# REVIEW COMMENTS

<b>Project:</b>		<i>In-N-Out (Gibson)</i>		<b>PDE:</b>		
<b>Review:</b>		<i>Draft Dated 10/29/2024</i>		<b>Reviewers:</b>		
<b>Date:</b>		<i>2/12/2025</i>		<i>Curtis Cherne, PE for CABQ Philip Gallegos, PE (Wilson &amp; Co) for NMDOT</i>		
<b>#</b>	<b>PAGE</b>	<b>SECTION</b>	<b>COMMENT</b>	<b>AGENCY</b>	<b>STATUS</b>	<b>RESPONSE</b>
1			Trips were assigned to a driveway three, which does not exist. See HCS Two-Way Stop-Control Report pp 130 and 131, 158 and 159 of 173. Reassign trips to the two driveways shown on the Site Plan. Additional comments/questions may arise after the revised information is presented.	CABQ	Agree	No trips were assigned to DWY 3 in report body, they were assigned as stated in the report. Errant old HCS reports were found in the appendix and removed.
2			The queue and delays for Alumni Dr SBL will most likely be long. With a long SBL queue and delay, drivers may make a SBR onto Gibson Blvd then execute a U-turn at Mulberry Dr. Provide a discussion and recommendation(s), if any, to reduce the queue for the Alumni Dr SBL and to mitigate the U-turn at Gibson Blvd and Mulberry Dr.	CABQ	Agree	Added U-turn to discussion on page 40 and updated rec

TRAFFIC CIRCULATION PLAN
 1 OF 2

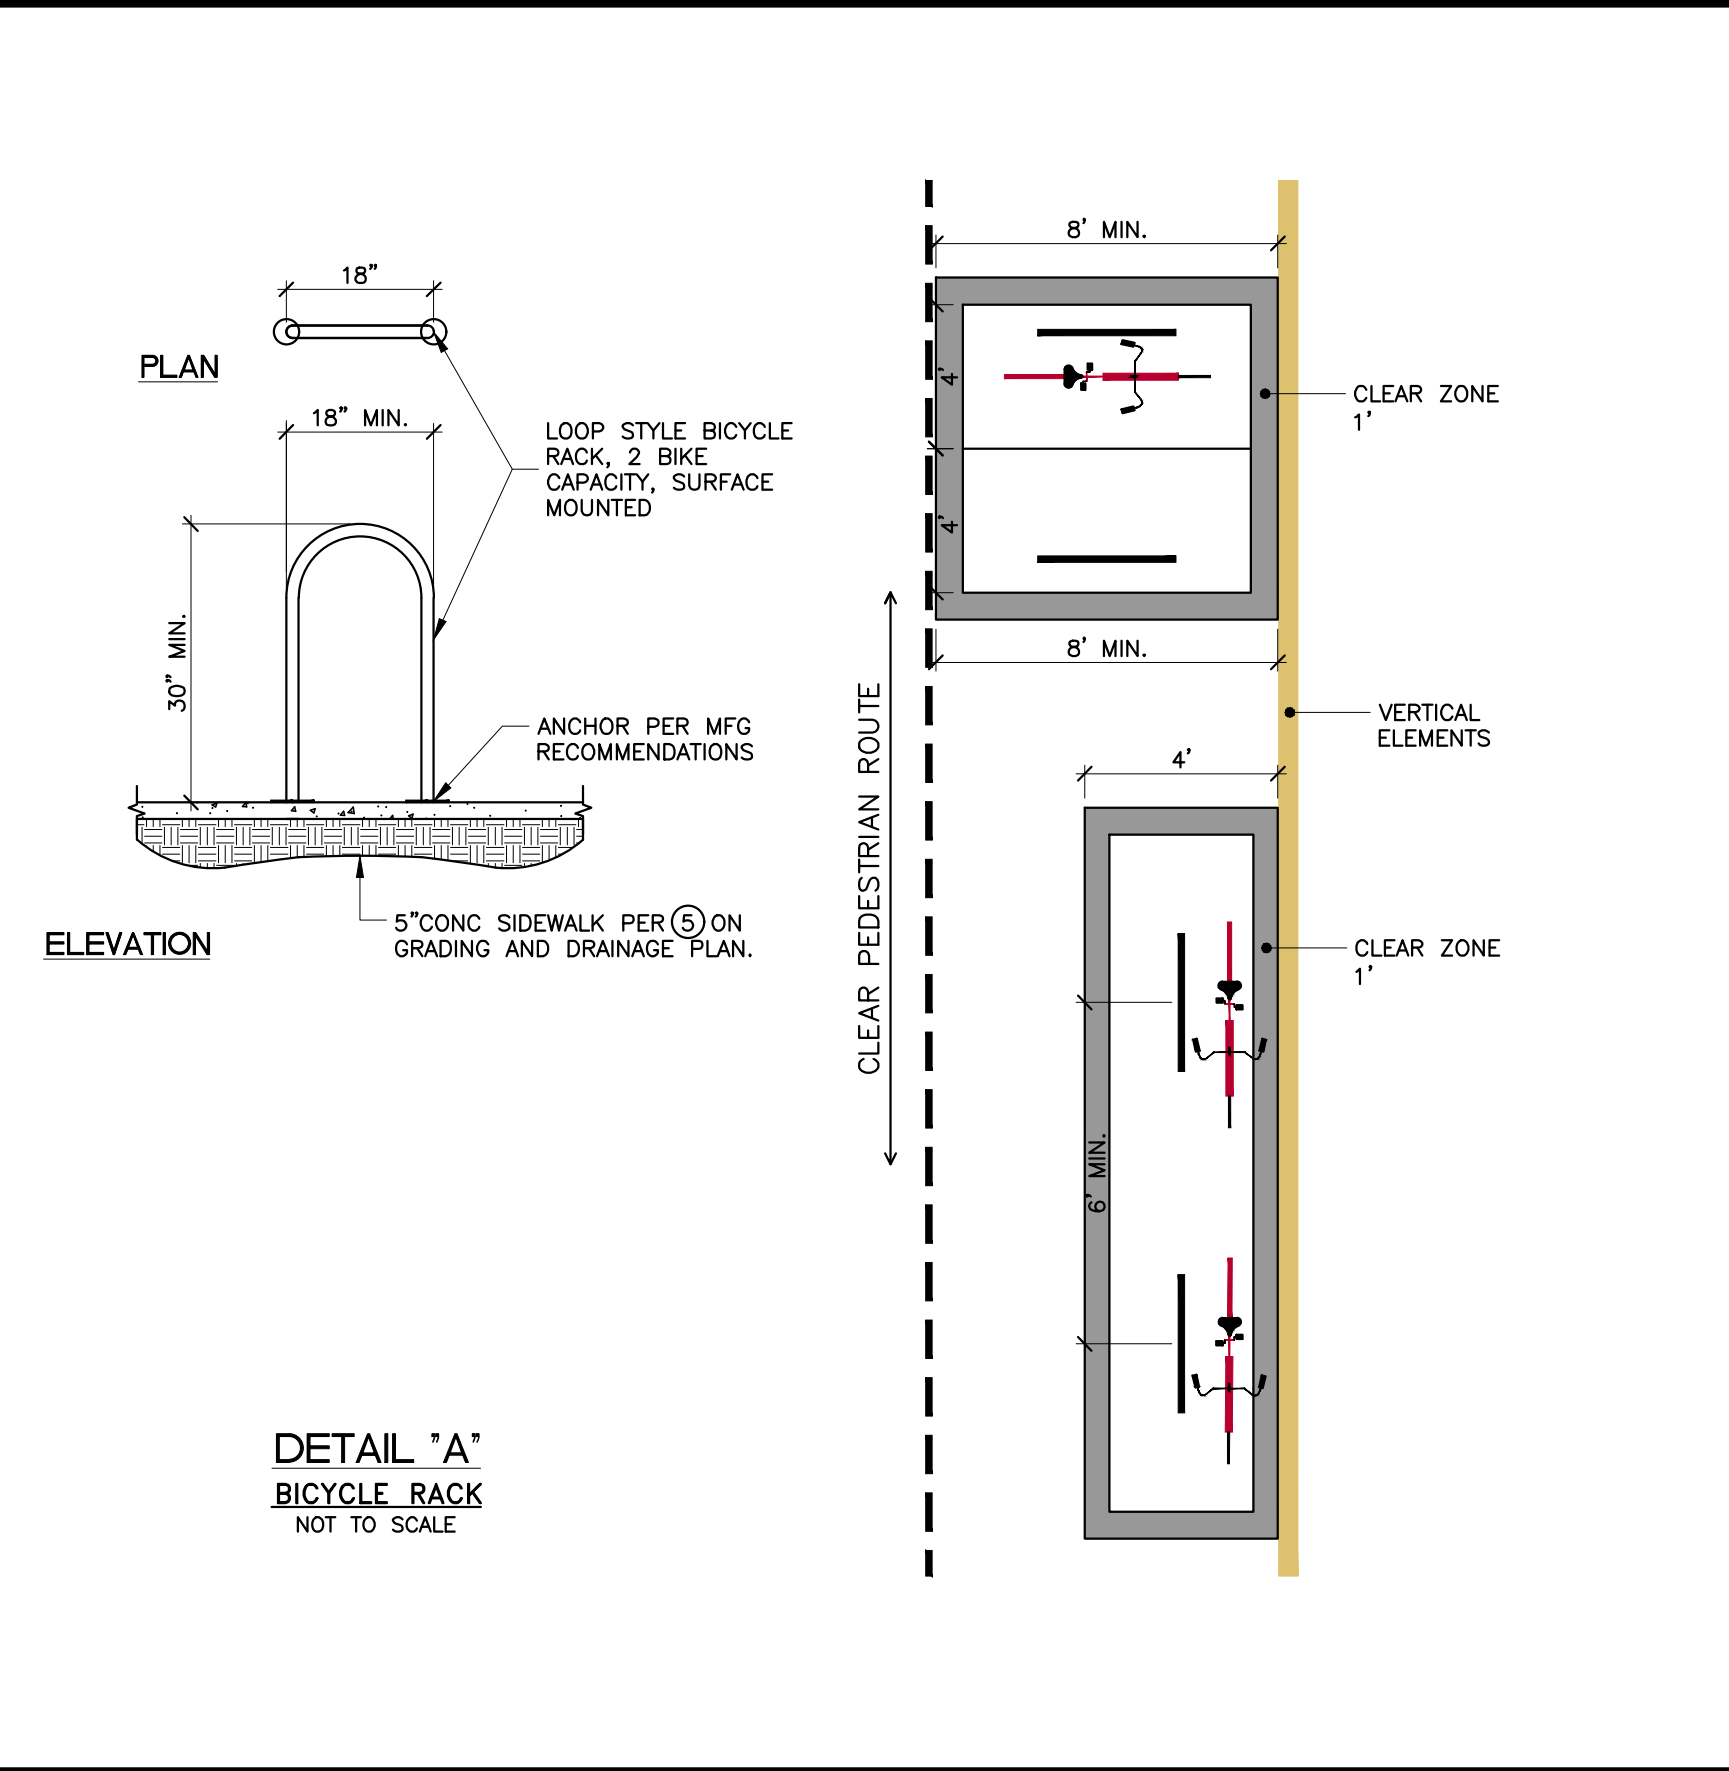
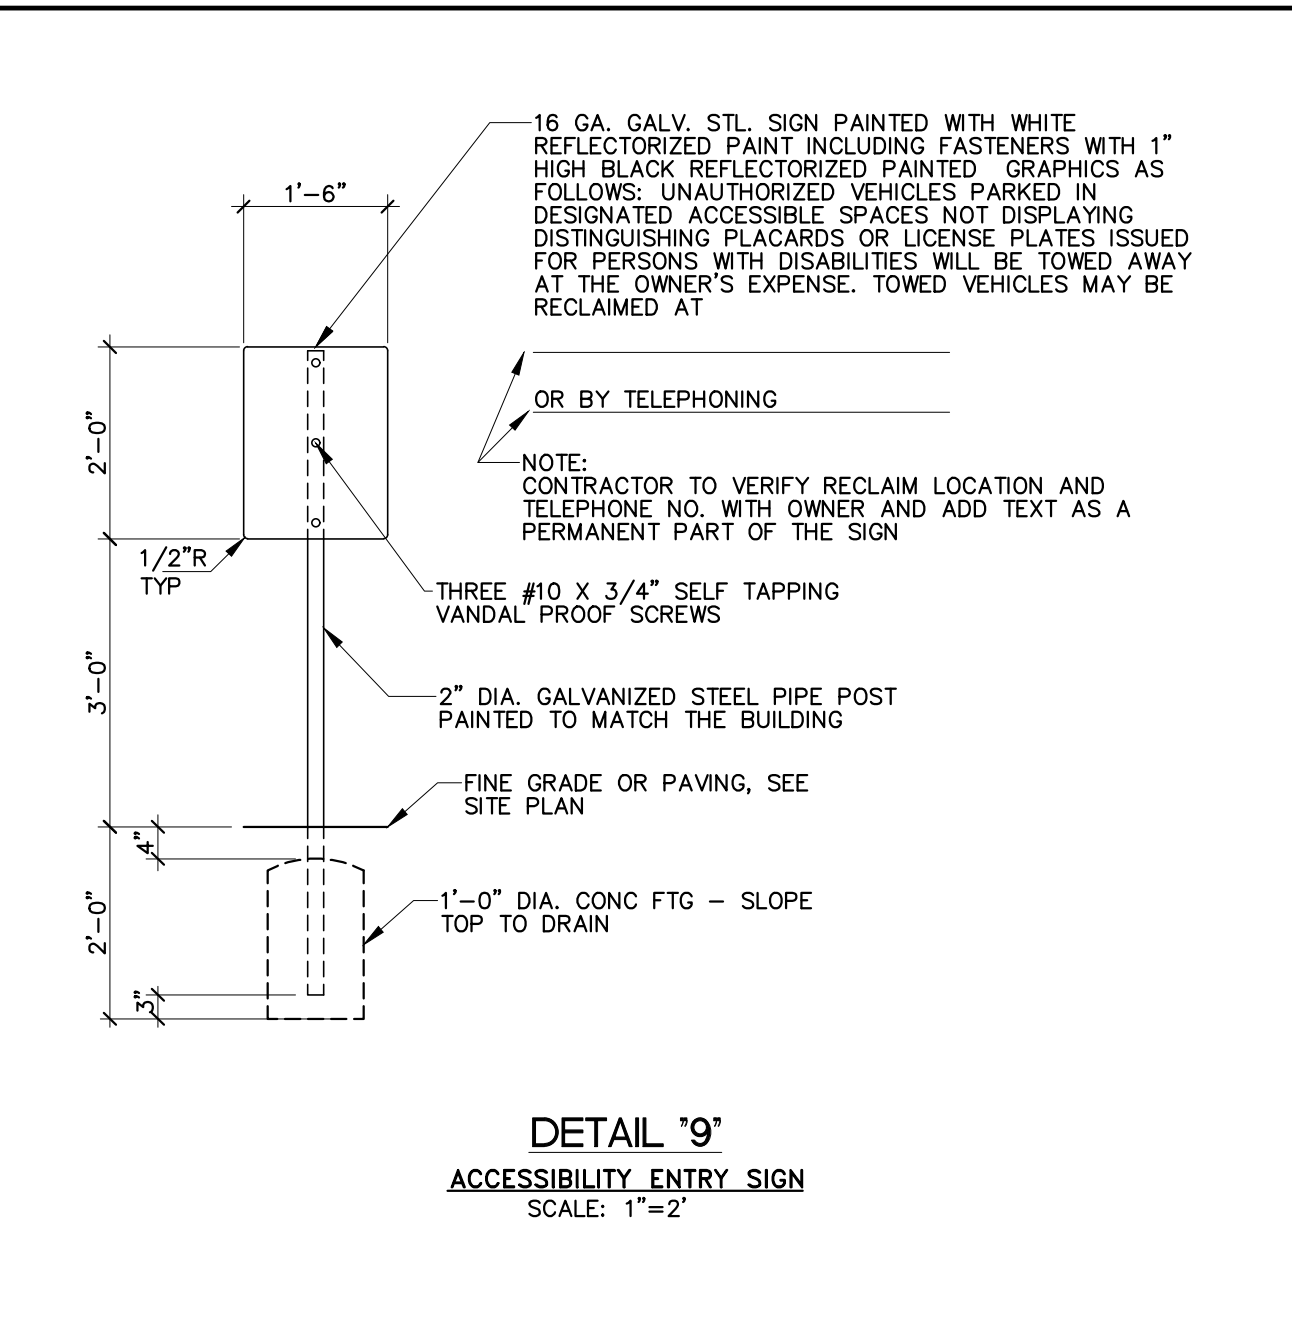
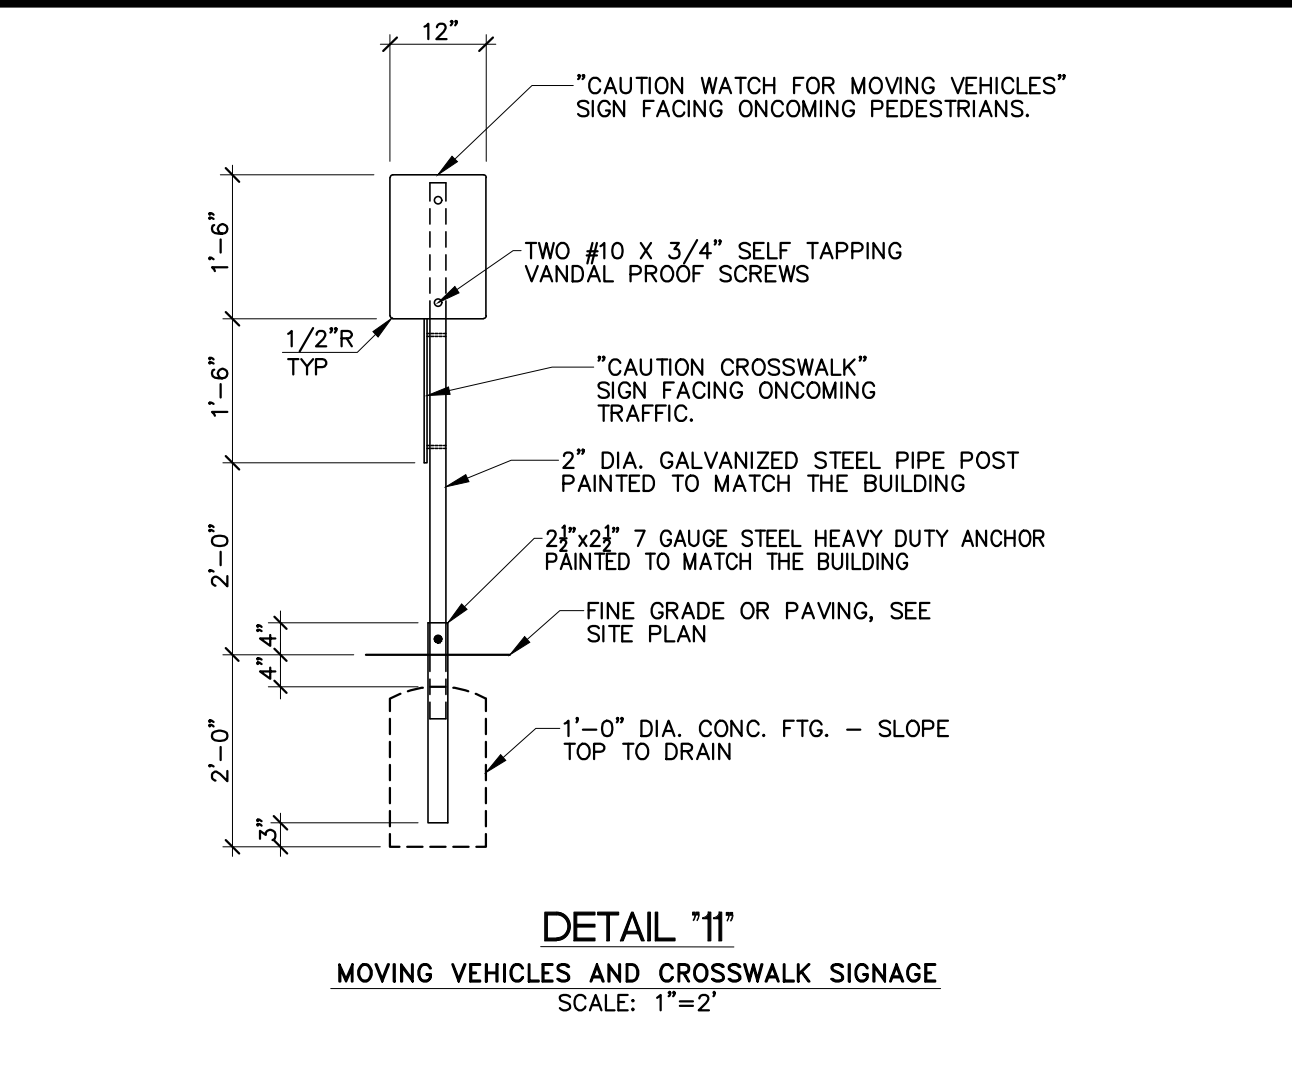
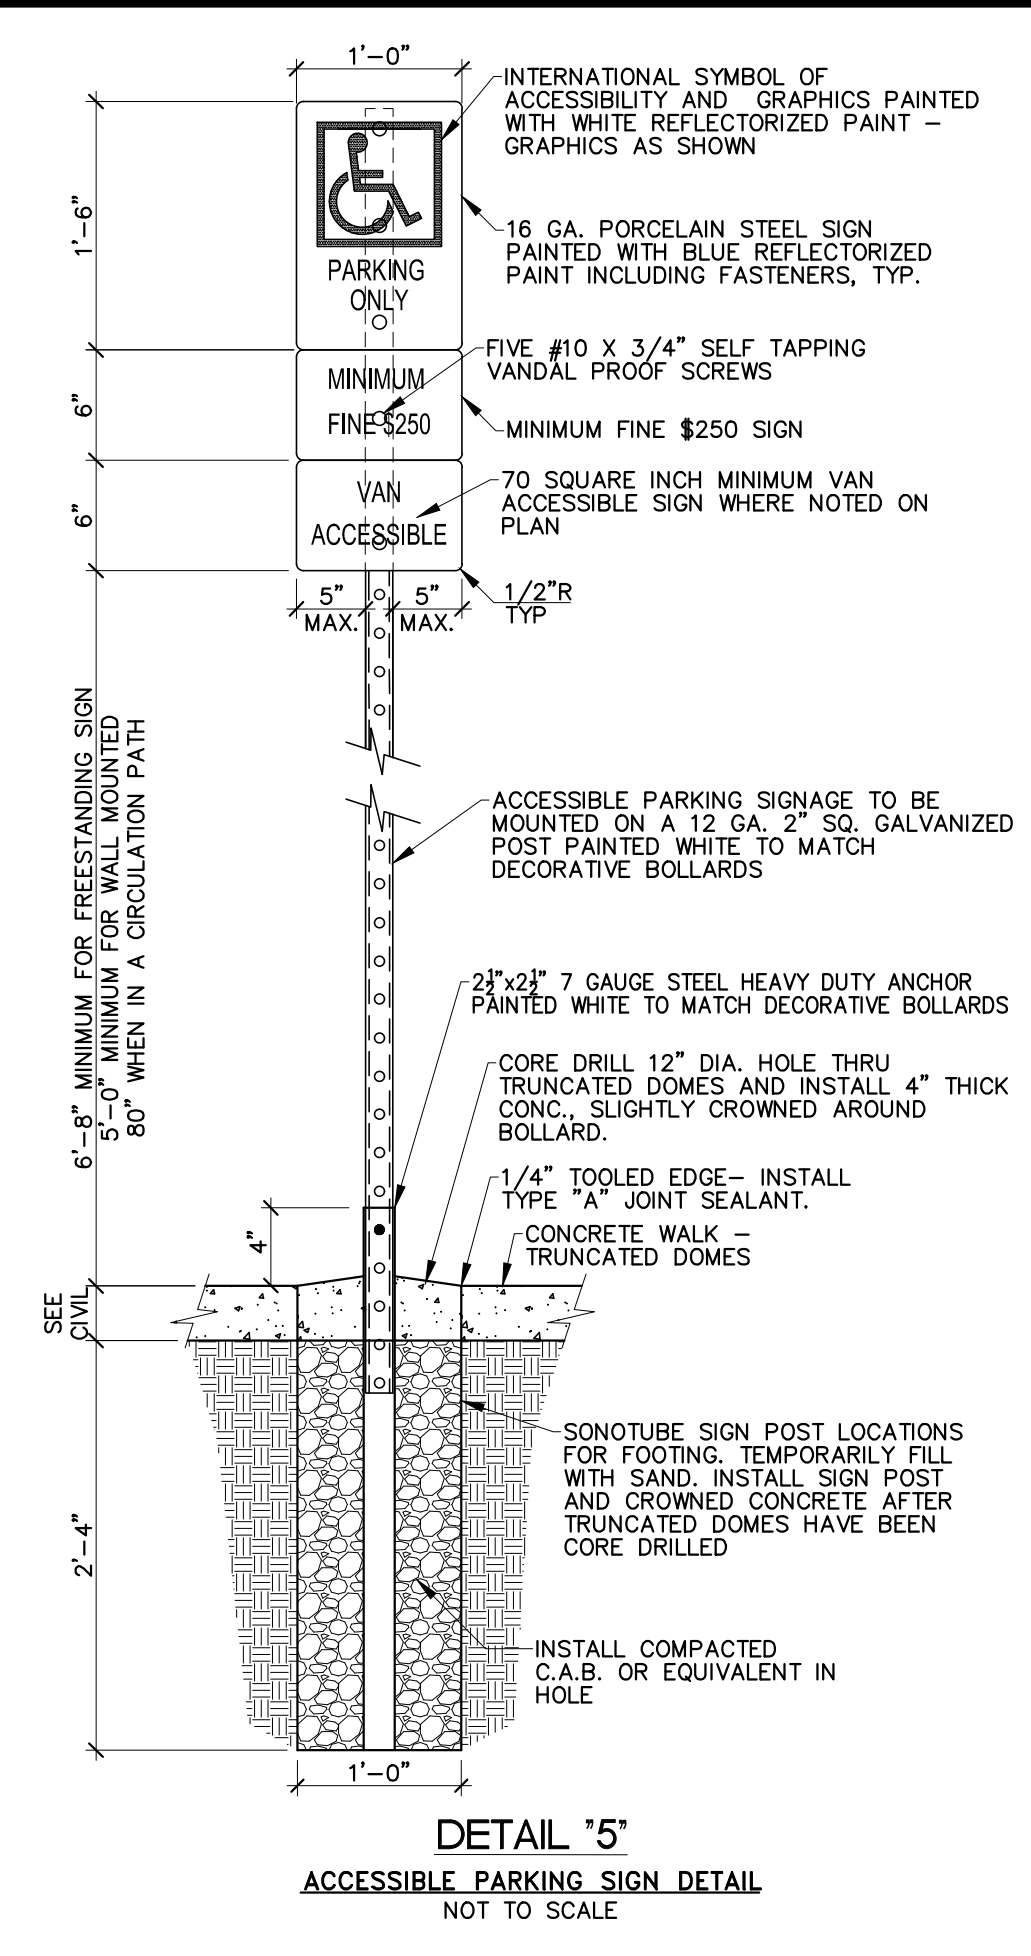
3			The Site Access and Justification paragraph mentions three access driveways, whereas, the Site Plan shows 2.	CABQ	Agree	Corrected.
4			Provide the methodology/calculations used to determine the 160 ft turn lane length: decel, storage and taper or 95% percentile queue length.	CABQ	No Action	No Action. The methodology is stated on Page 26 before Table 8.
5			Provide a clear 11” x17” site plan that shows the dimensions and striping discussed in the Auxiliary Lane Analysis section.	CABQ	Agree	In N Out has provided new stand-alone site plan.
6			Need vicinity map and legal description of the project in the introduction section as required by the NMDOT TIS Outline.	NMDOT	Agree	Vicinity Map shown in figure 2. Added legal description.
7			In the executive summary it refers to site access as being one on Gibson Blvd and 2 on Alumni Drive. Per NMDOT guidance the only access is to be on Alumni Drive which is reflected in the body of the report. Reference to site access on Gibson Blvd should be removed.	NMDOT	No Action	Report delivered on 2/14/2025 addressed this issue.
